FLYING HORSE NORTH FILING NO. 5 CONSTRUCTION DOCUMENTS

COVER & LEGEND
COVER

SHEET
ST
 4

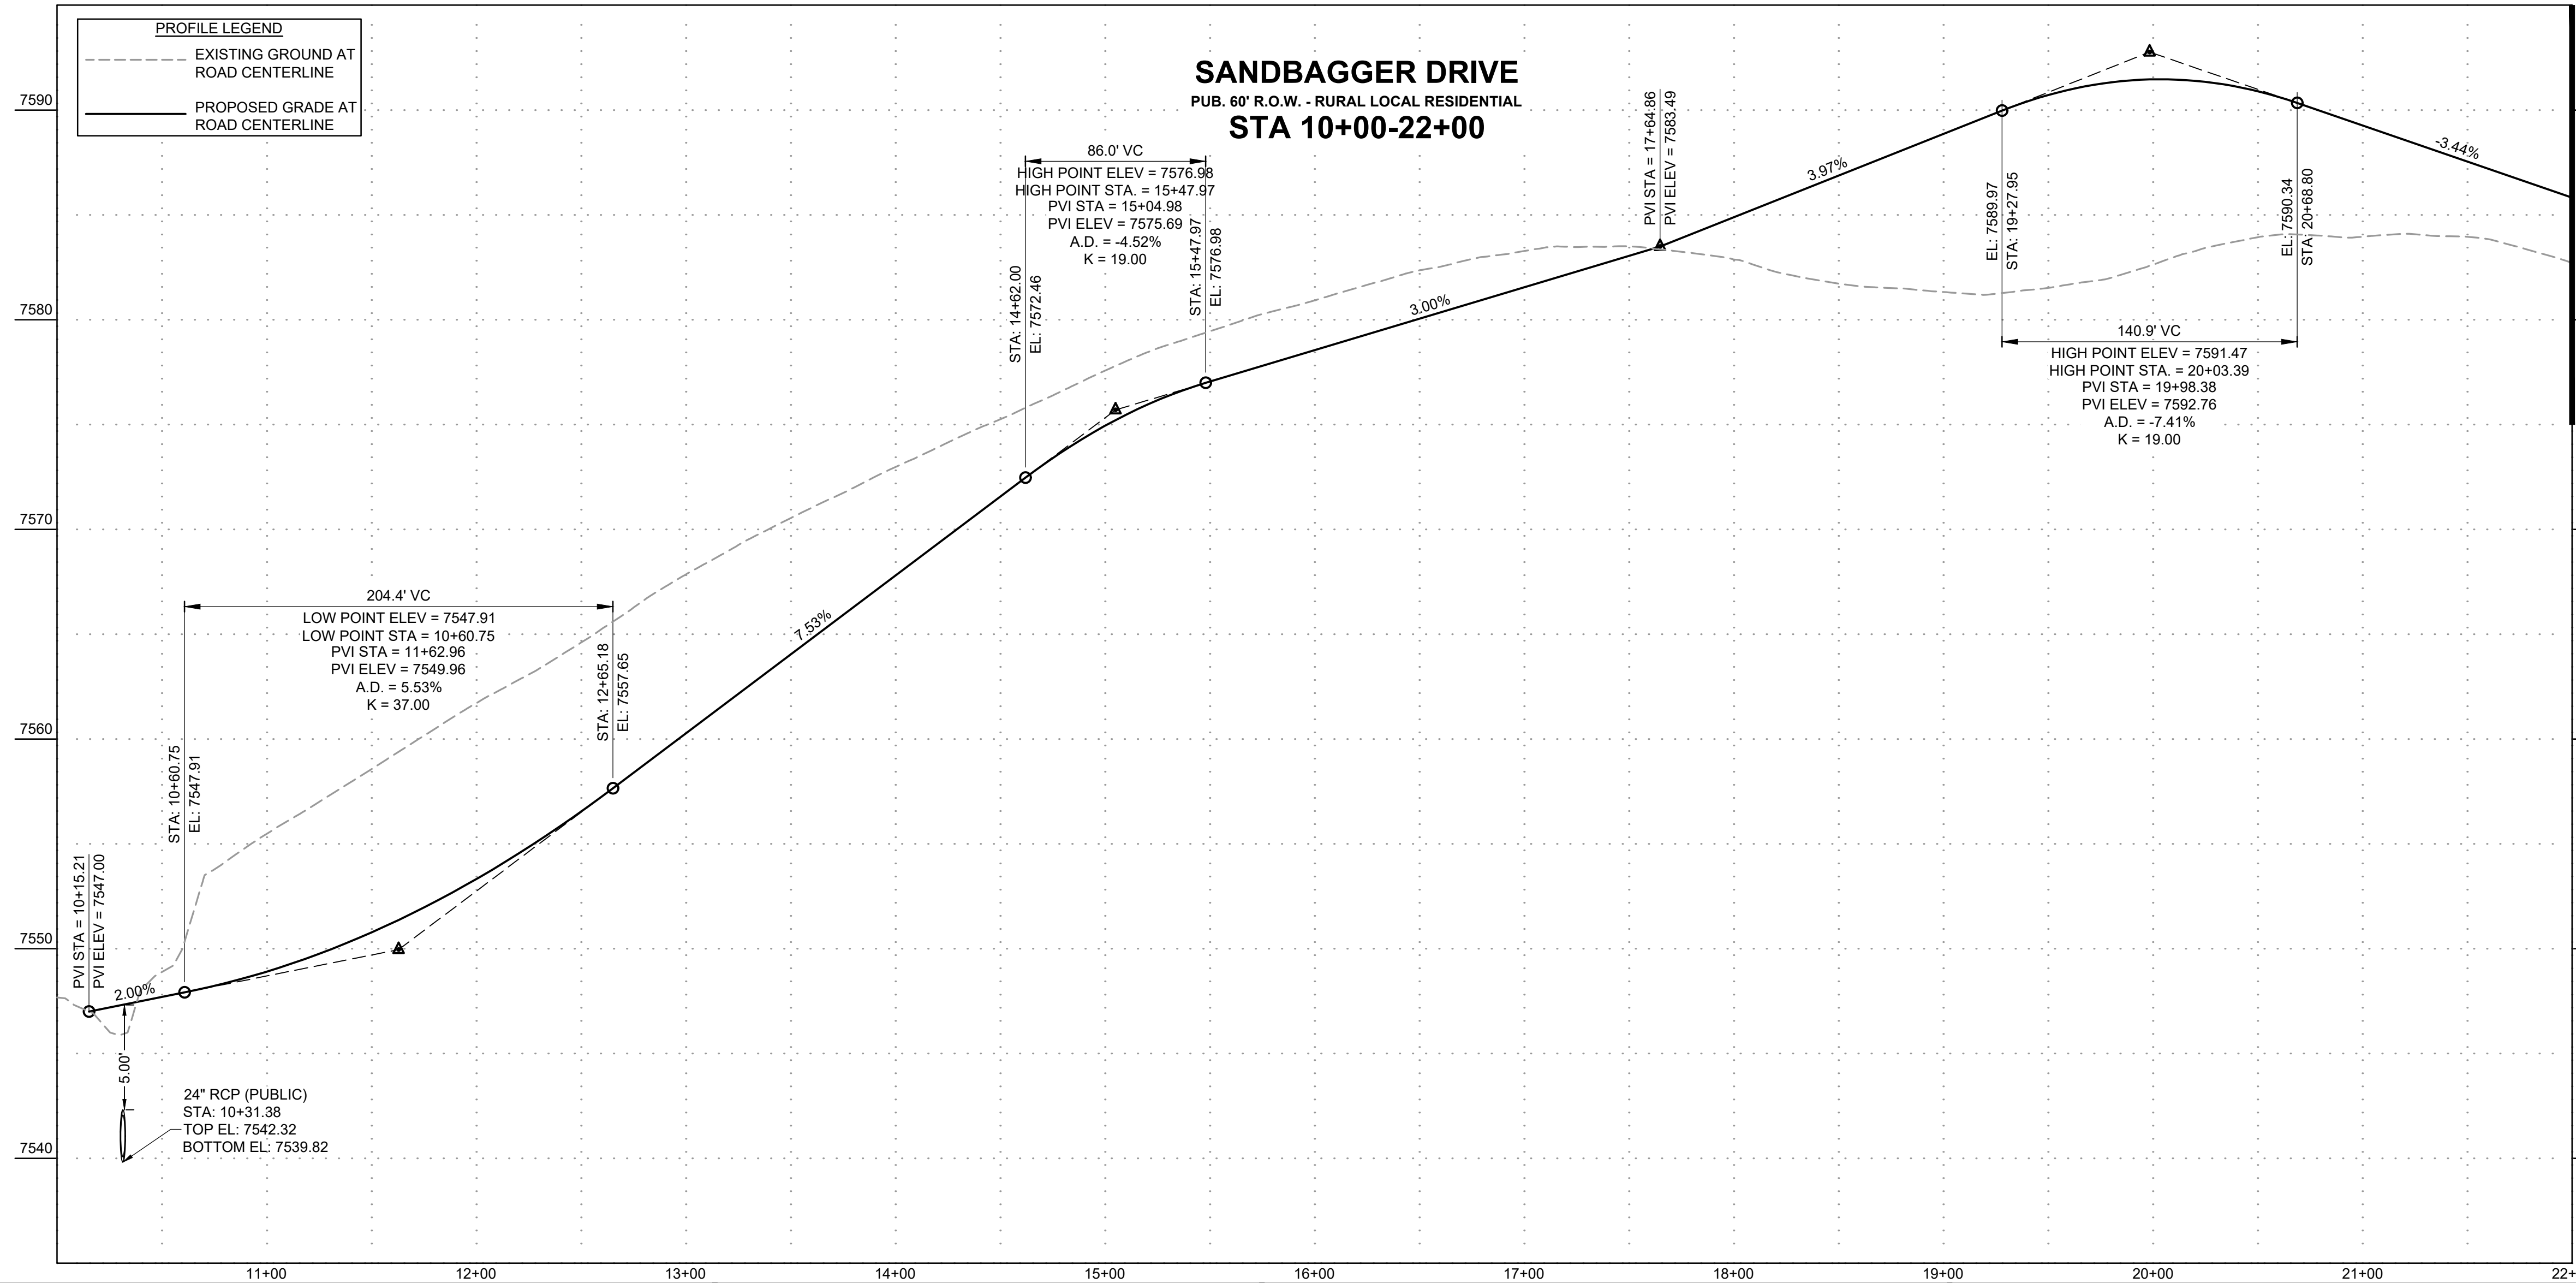
Please modify the filing boundary or provide easement for the temporary CDS to be constructed outside for the filing boundary, ECM 2.3.8

HRG RESPONSE: TEMPORARY CONSTRUCTION EASEMENT TO BE USED, NO MODIFICATION TO THE FILING BOUNDARY NEEDED, THE LINEWORK SHOWN ON THE CD'S IS CORRECT, PLAT TO BE ADJUSTED.

SANDBAGGER DRIVE
 PUB. 60' R.O.W. - RURAL LOCAL RESIDENTIAL
 STA 10+00-17+50

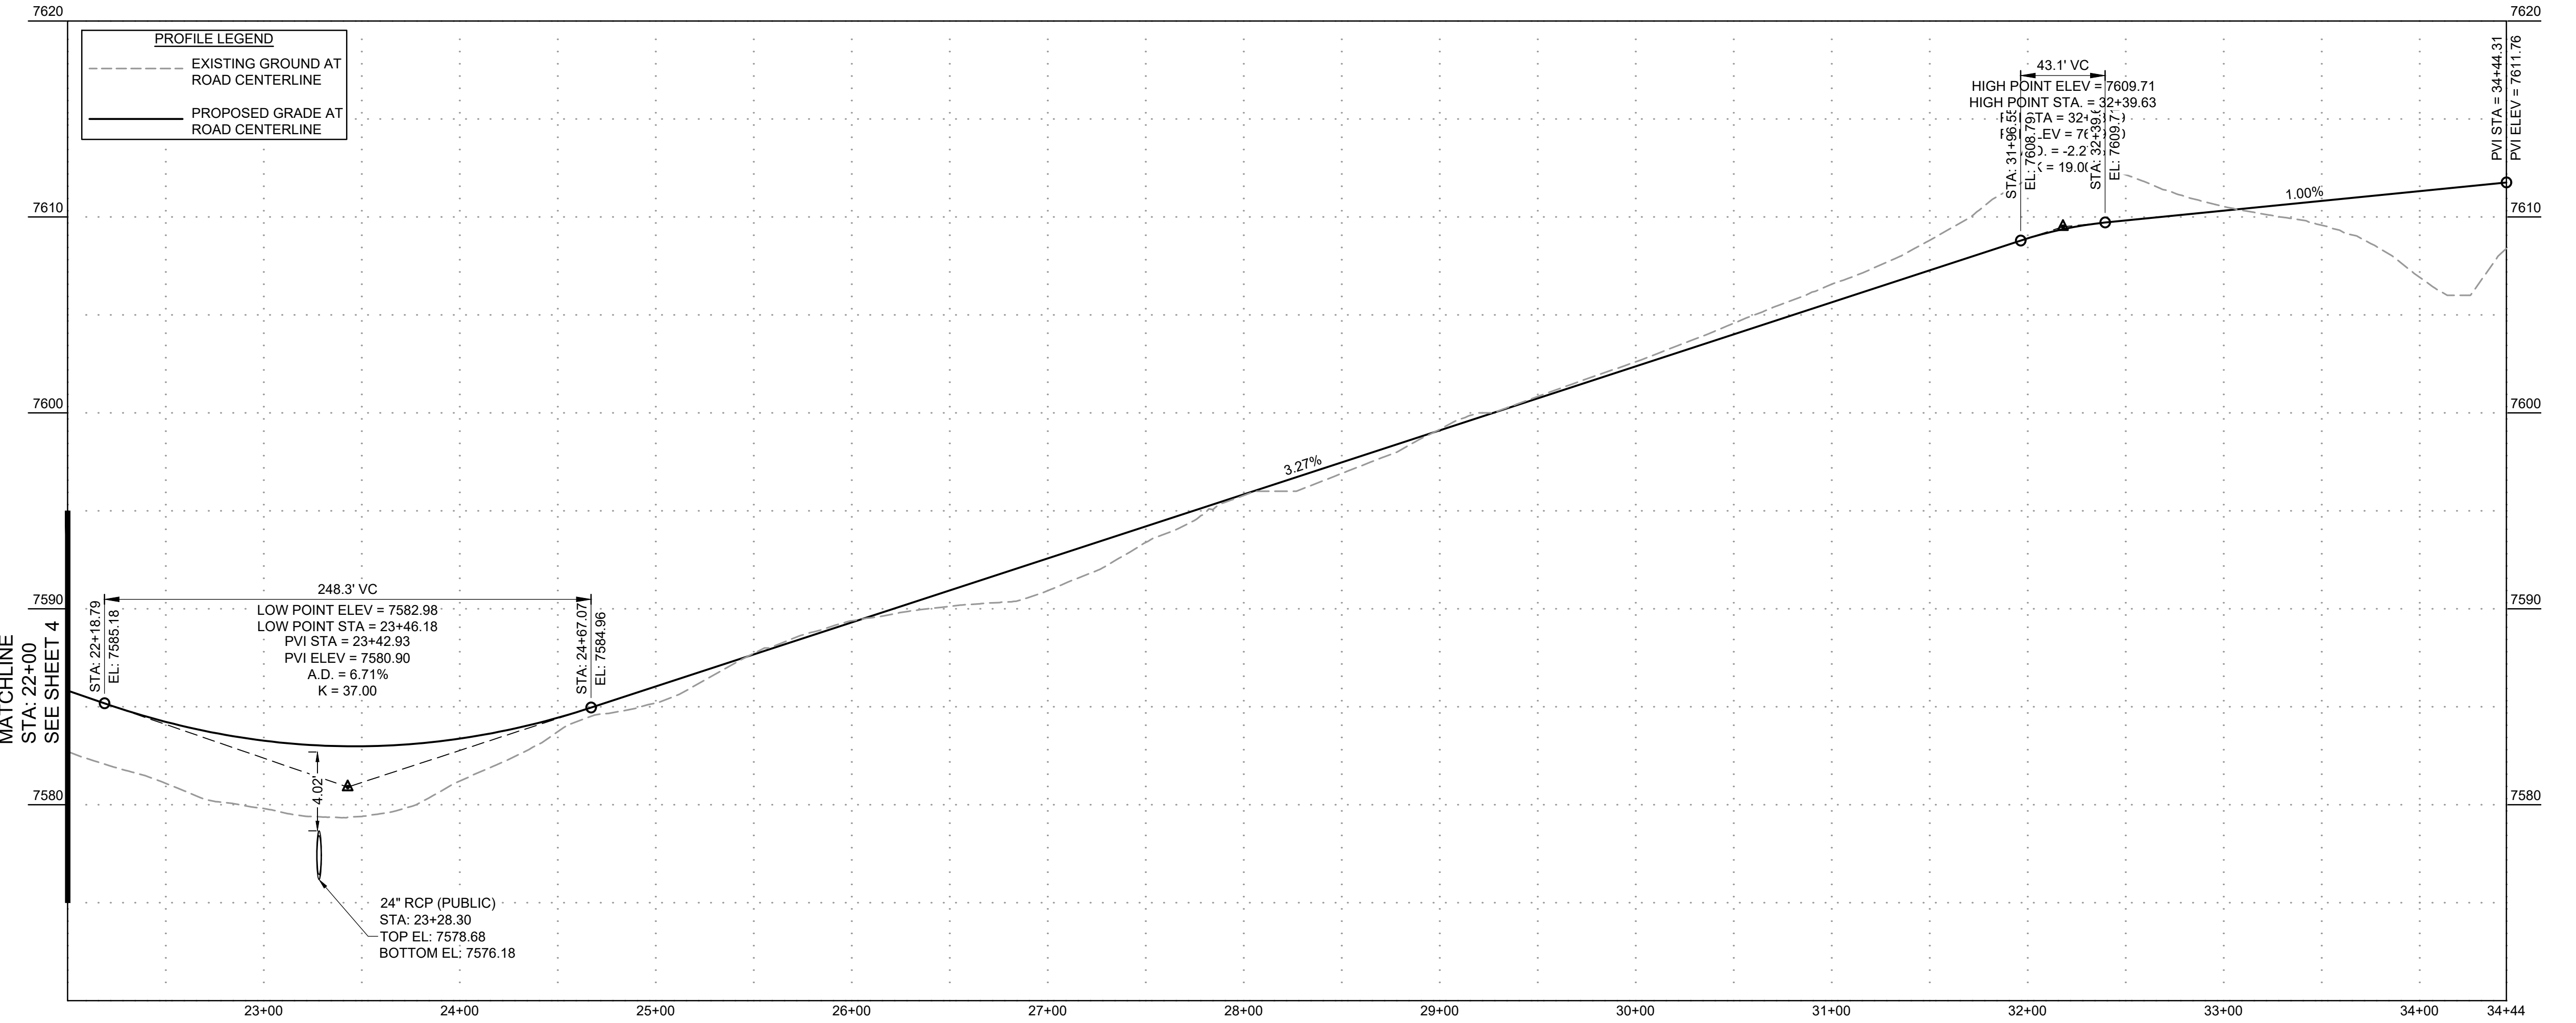
Revise stationing

HRG RESPONSE: STATIONING REVISED.
